**Yorkshire Water Services
Developer Services
Sewerage Technical Team
PO BOX 52
Bradford
BD3 7AY**

**Your Ref: 2026/0420
Our Ref: B/02221**

Land west of Sheffield Road, Birdwell, Barnsley – (BARNs) Erection of 10 two and three storey detached dwellings

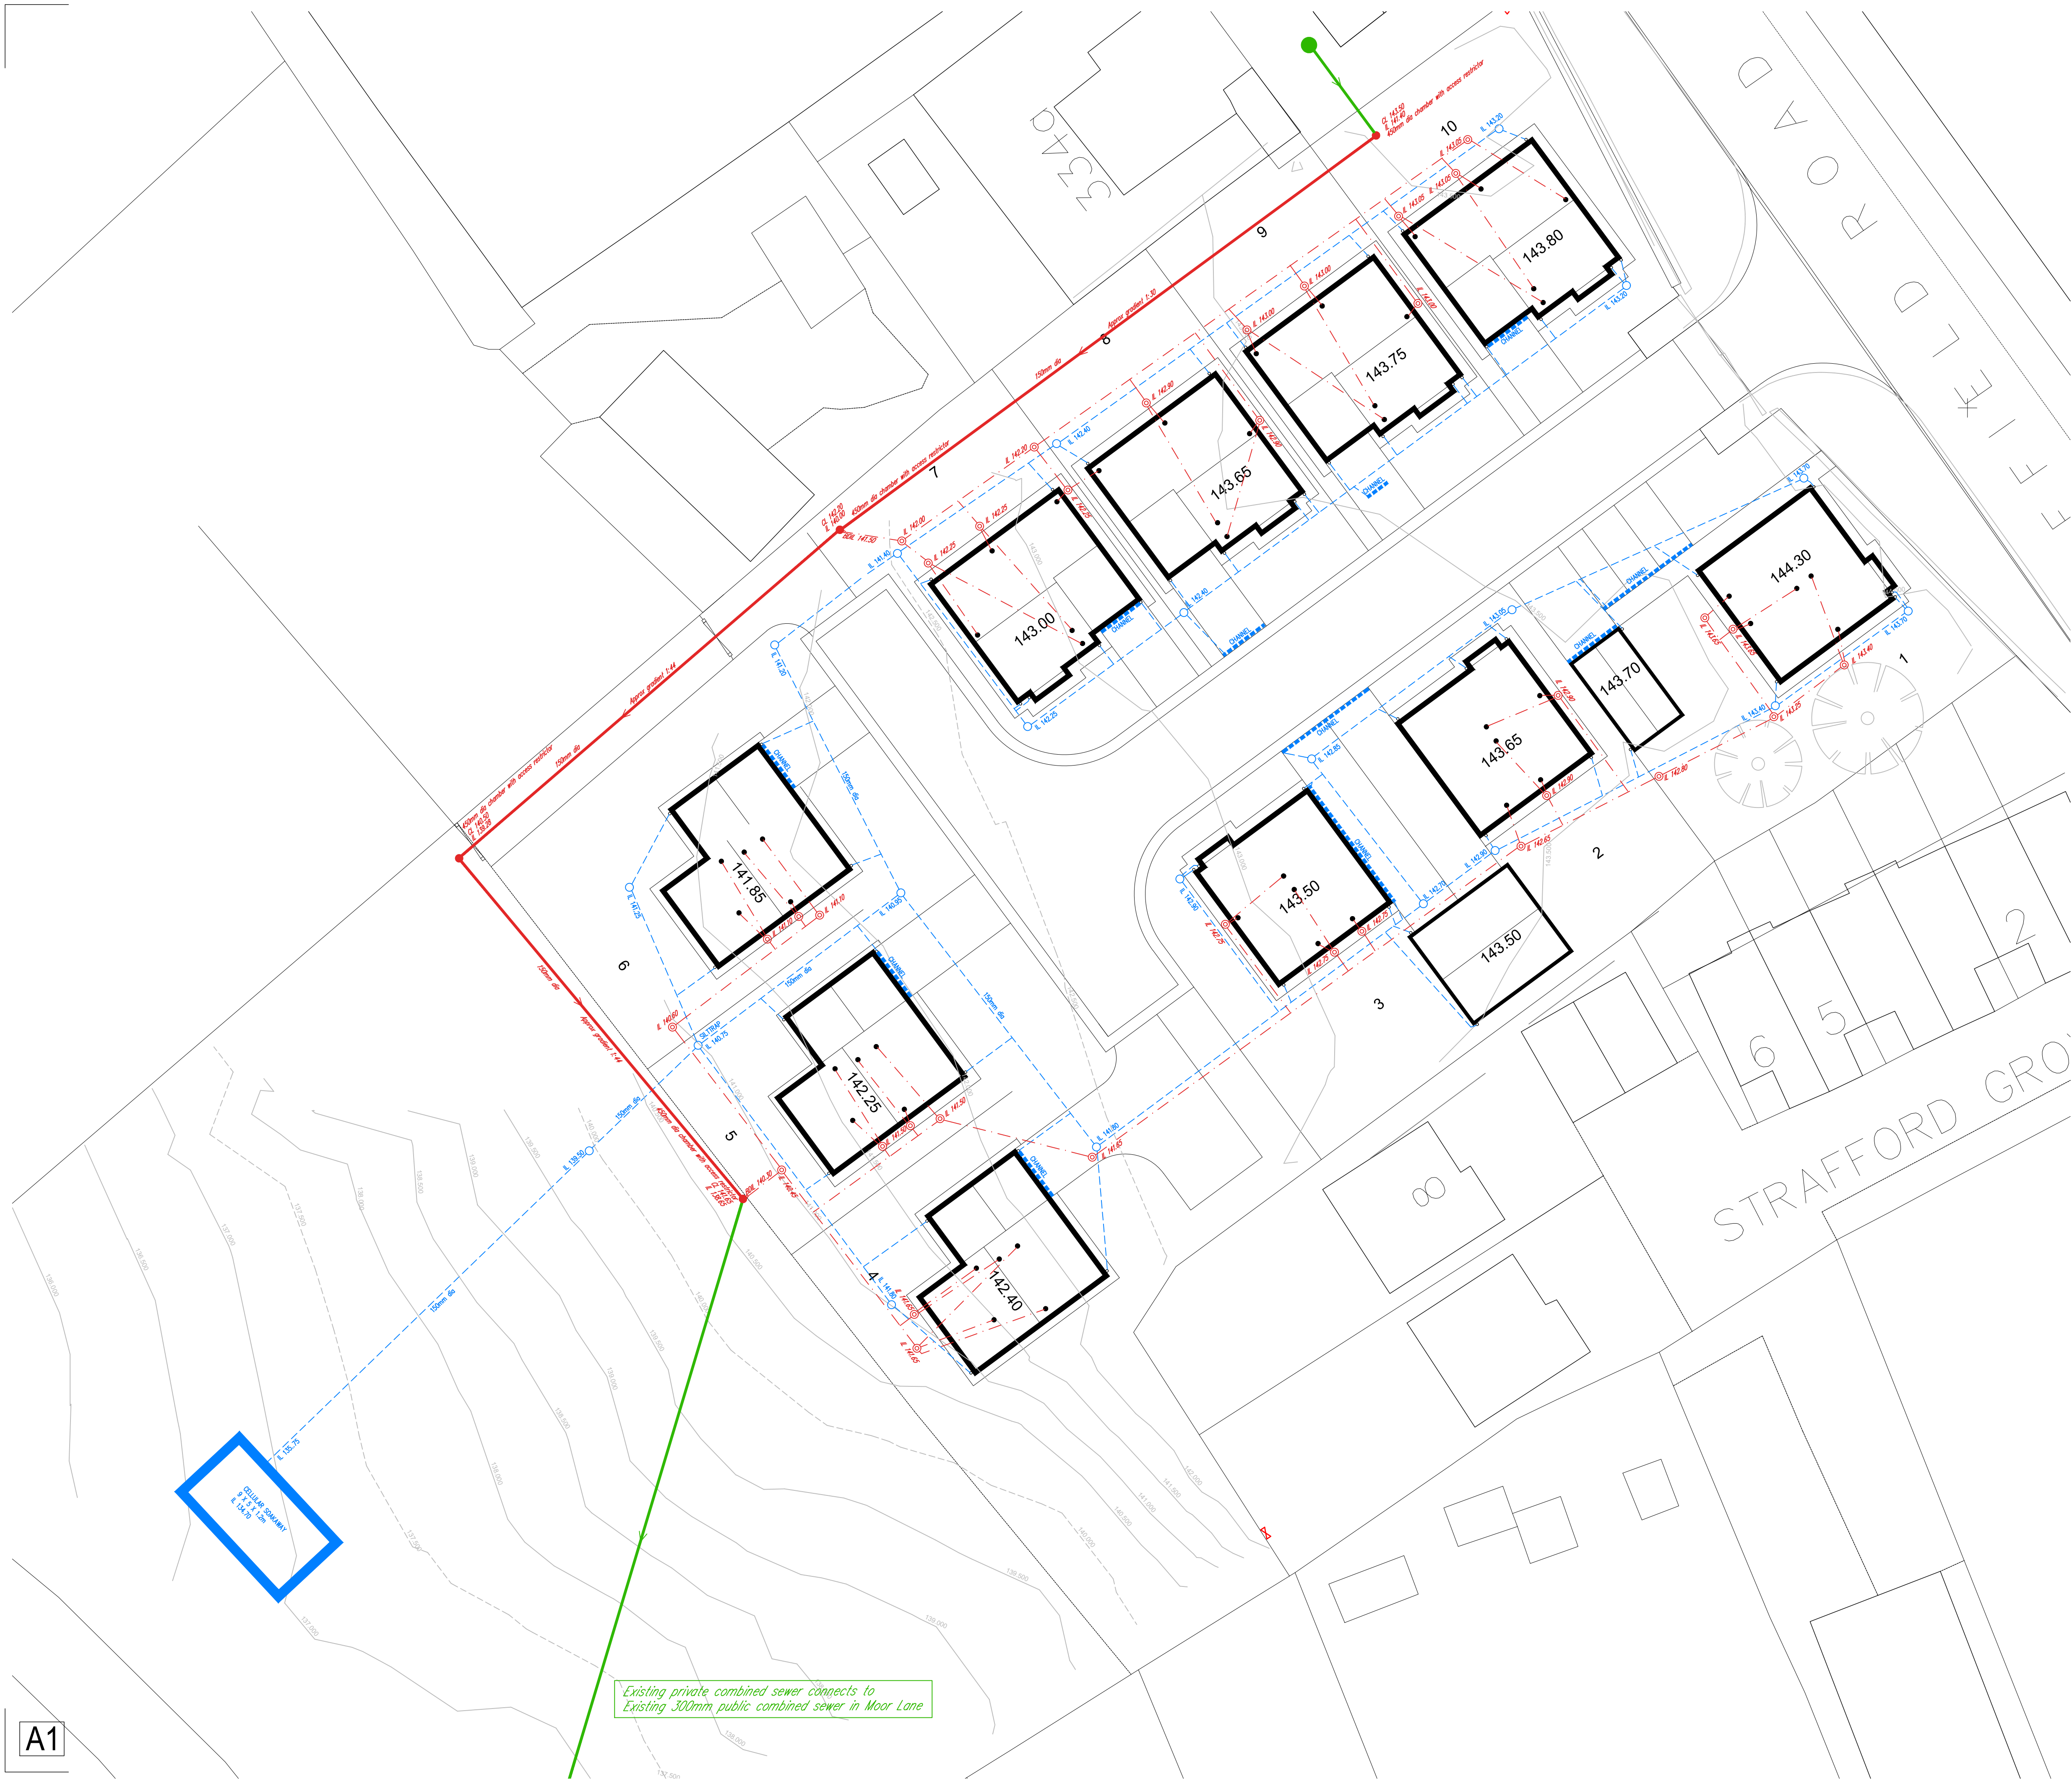
- 1.) Yorkshire Water has no objection in principle to the drainage details submitted on drawing 'Plot Drainage' STE/26/14/09 dated 30/06/26 that has been prepared by Shaun Tonge namely:
 - a.) The proposed separate systems of drainage on site and off site.
 - b.) The proposed amount of domestic foul water to be discharged to the public combined water sewer
 - c.) The proposed amount of curtilage surface water to be discharged to soakaway.

As our powers under the Water Industry Act are limited it is important to ensure explicit control over the approach to foul water disposal in any planning permission. As such the foul water discharge as shown in the above-mentioned drawing is acceptable.

It is noted from the submitted planning application that surface water is proposed to be drained to soakaway – Yorkshire Water fully endorse this means of surface water disposal.

As surface water from the site is not proposed to discharge to the public sewer network, no assessment of the capacity of the public sewers to receive surface water has been undertaken. Should the surface water disposal proposals change, further consultation with Yorkshire Water will be required.

The development shall be carried out in accordance with the details shown on the submitted plan, " 'Plot Drainage' STE/26/14/09 dated 30/06/26 that has been prepared by Shaun Tonge", unless otherwise agreed in writing with the Local Planning Authority.
